Date 19 October 2023
Our Ref 23/01224/FLH

Town and Country Planning Act 1990 (As Amended)
24 The Parade, Epsom, Surrey
Re-alignment of front garden wall, new gates across driveway, single storey rear extension and replacement windows to property

Proposed
floor plan

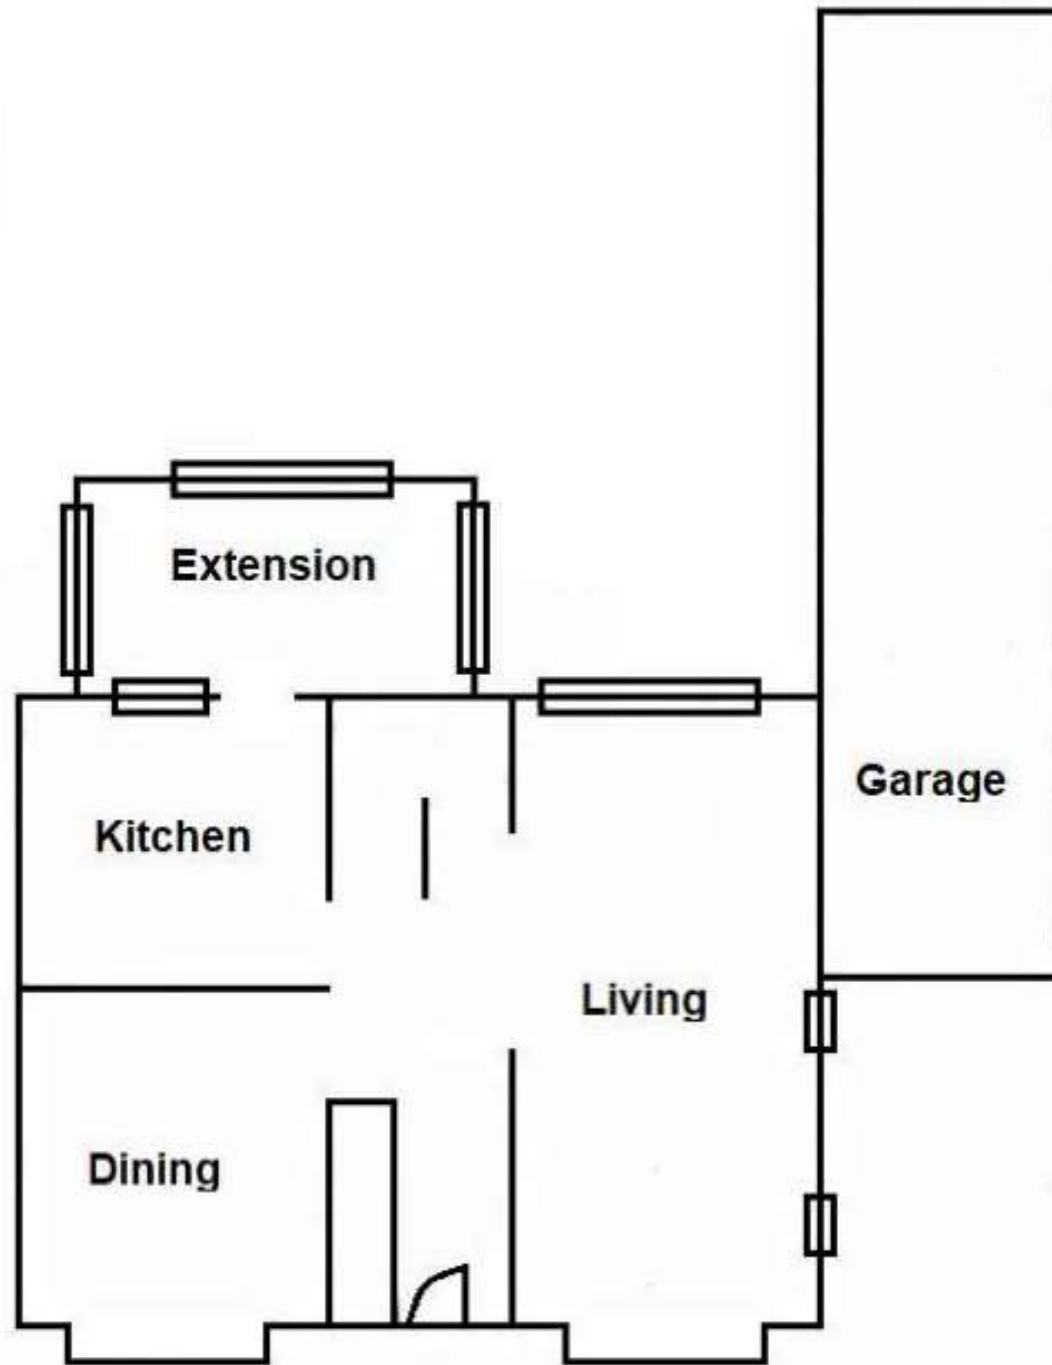
1 The application remains invalid as the proposed floor plan is incorrect. The extension elevations show windows and doors which need to be consistently identified on the proposed floor plan.
